March 5 2024
An Bord Pleanála
Oral Hearing 314724-22

Metrolink Module 1 AZ4(i)

Submission Report from

No 33 & 34 Dartmouth Road, Dublin 6.

Client	TII NTA	Project	METROLINK	Drawing Title	METROLINK - STRUCTURES CHARLEMONT STATION PROPOSED STREET LEVEL DESIGN	Drawing Status	S0
Consultant	JACOBS IDOM	Drawing N°	ML1-JAI-SRD-ROUT_XX-DR-Z-02090	Plan Drawing N°	ML-ST 307 O-A1		
		Scales Original Size A1	1:250			Sheet	1 of 6

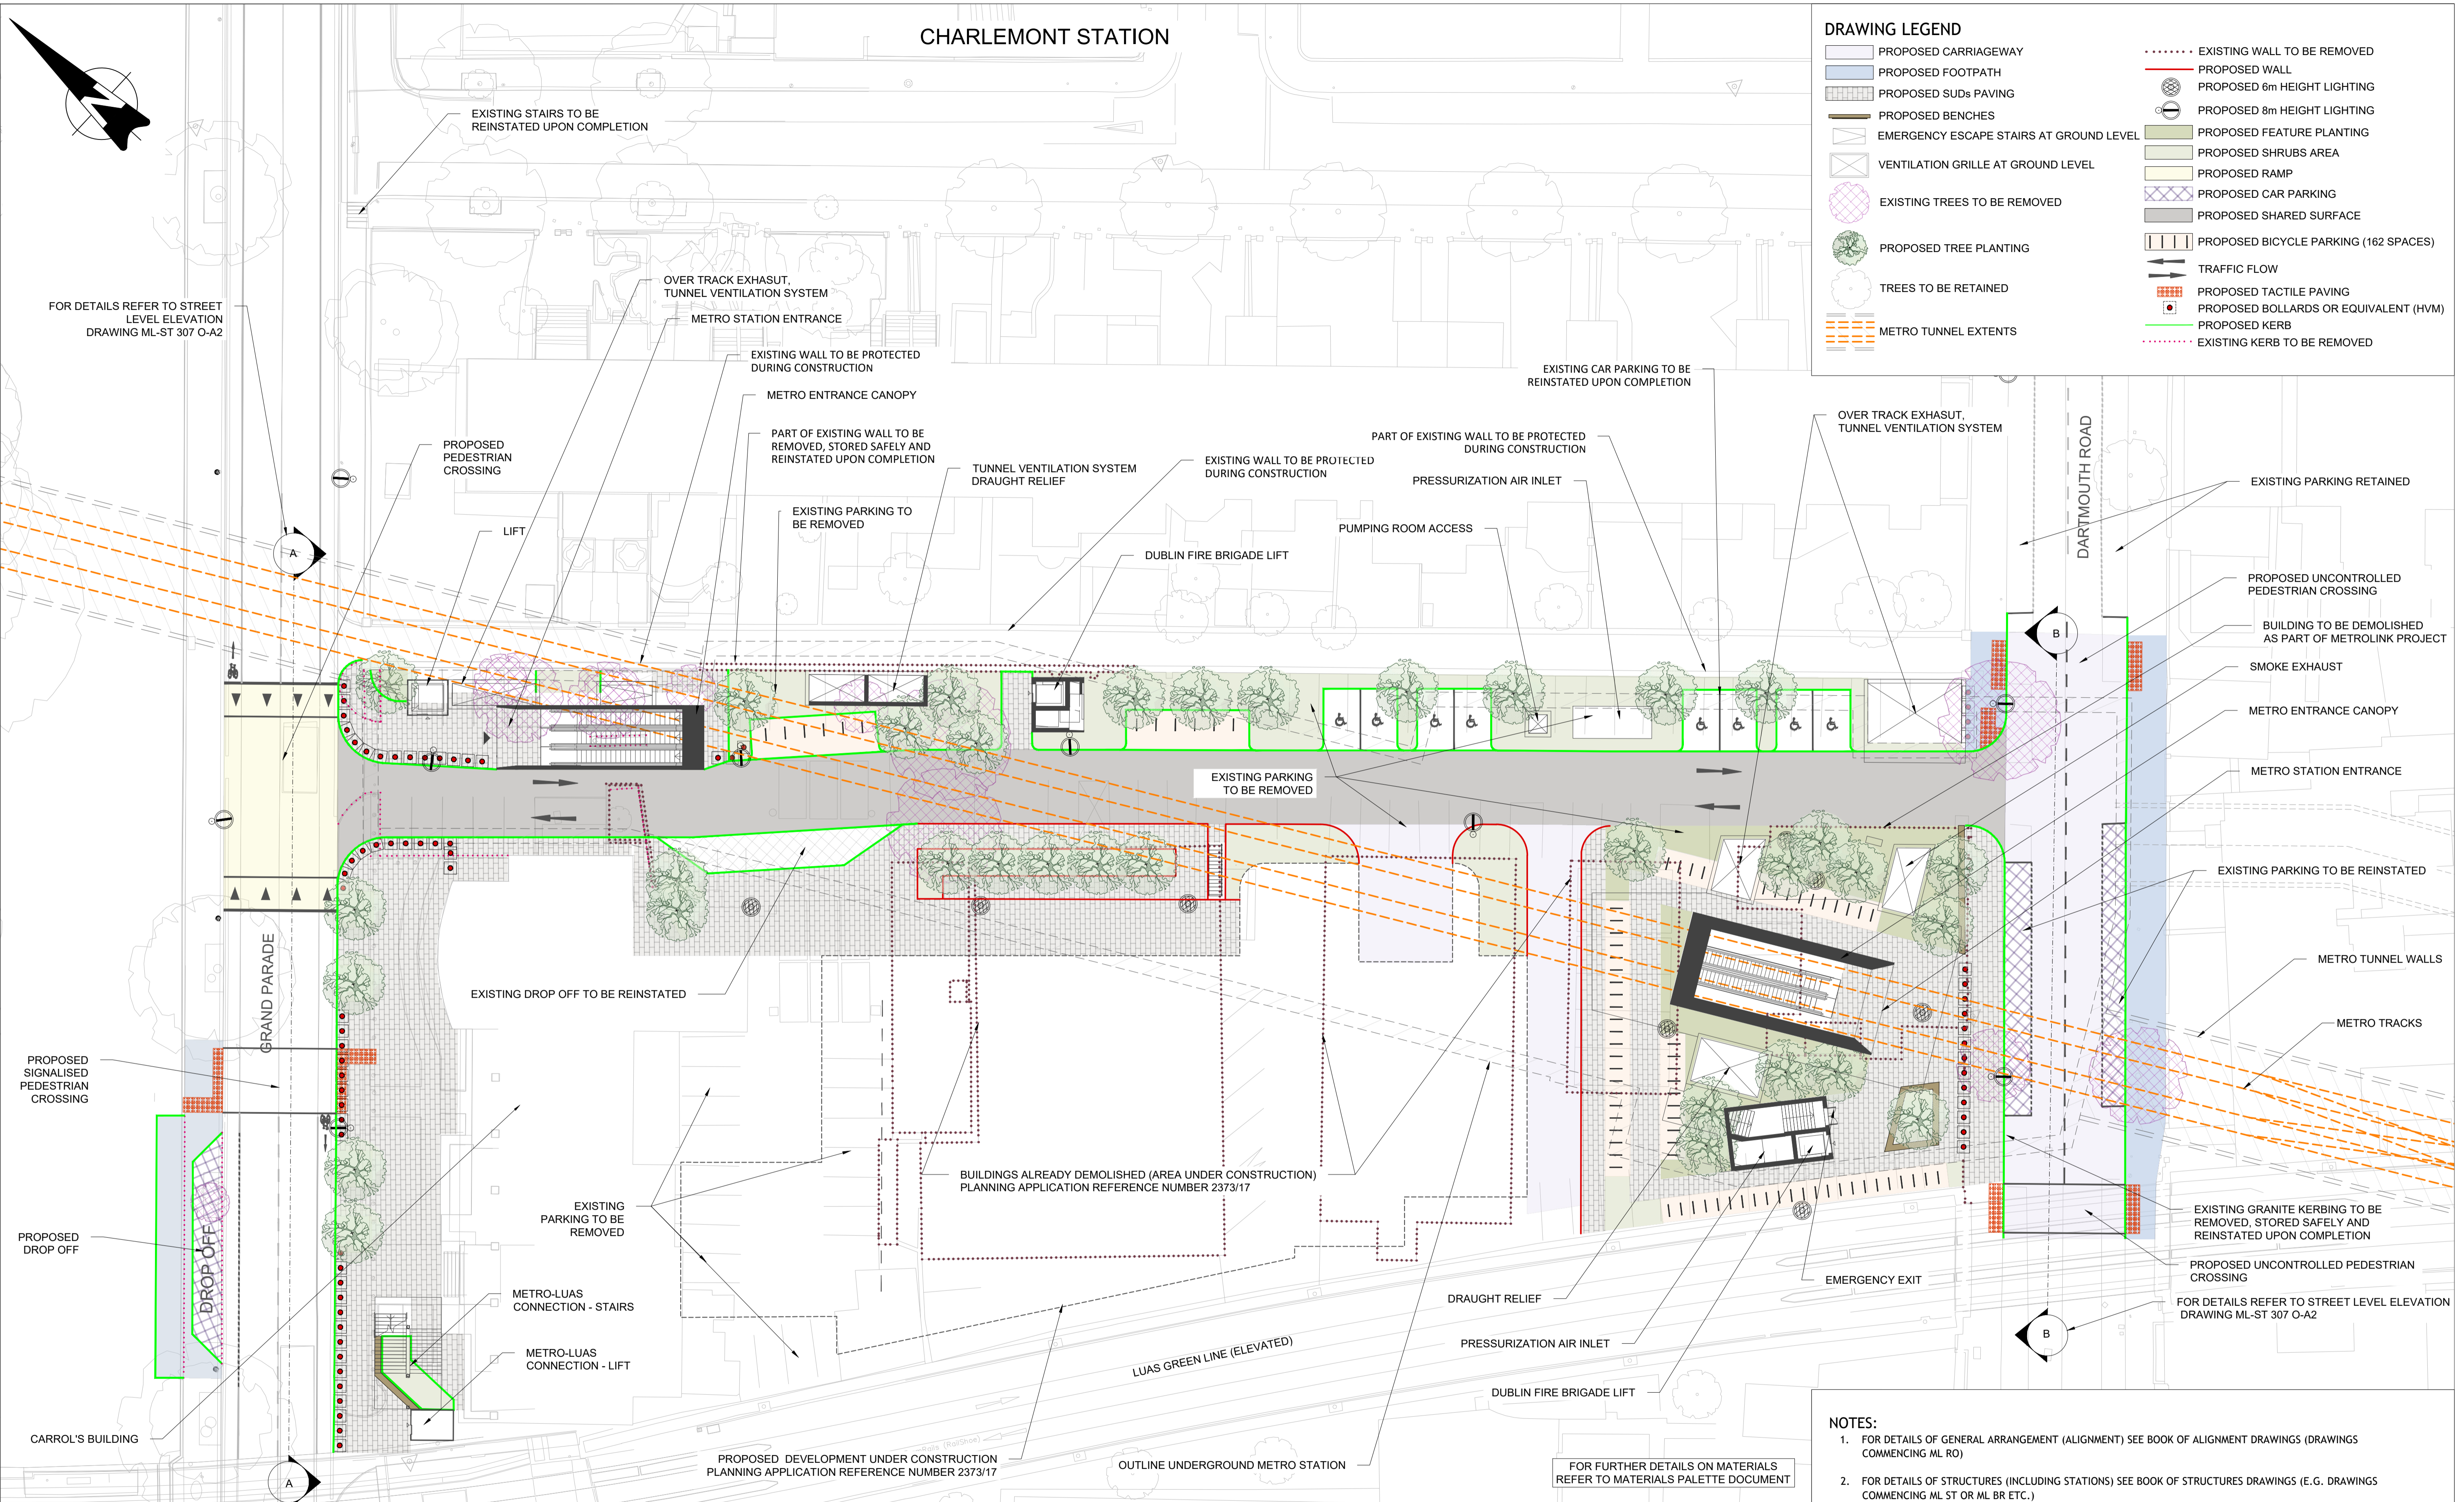
The excavation for Charlemont Station will be immediately in front of my clients' homes, approximately 1.8m from their front gates and approx 6.5m from their front doors and windows.

The boundary between the site/my clients' homes will comprise of a 4m high solid barrier.

The proposed construction works site and compound includes the full width of Dartmouth Road from the junction with Dartmouth Place to the junction with Cambridge Terrace. Initially during utility diversion, vehicle access to Nos 32-35 will be restricted but during the full road closure there will be no vehicle access. Vehicle access will not be possible until both the roof slab and the station, in that order, are completed. Utility diversion and station construction "anticipated to take up to four years" (EIAR 5.10.13 p107)
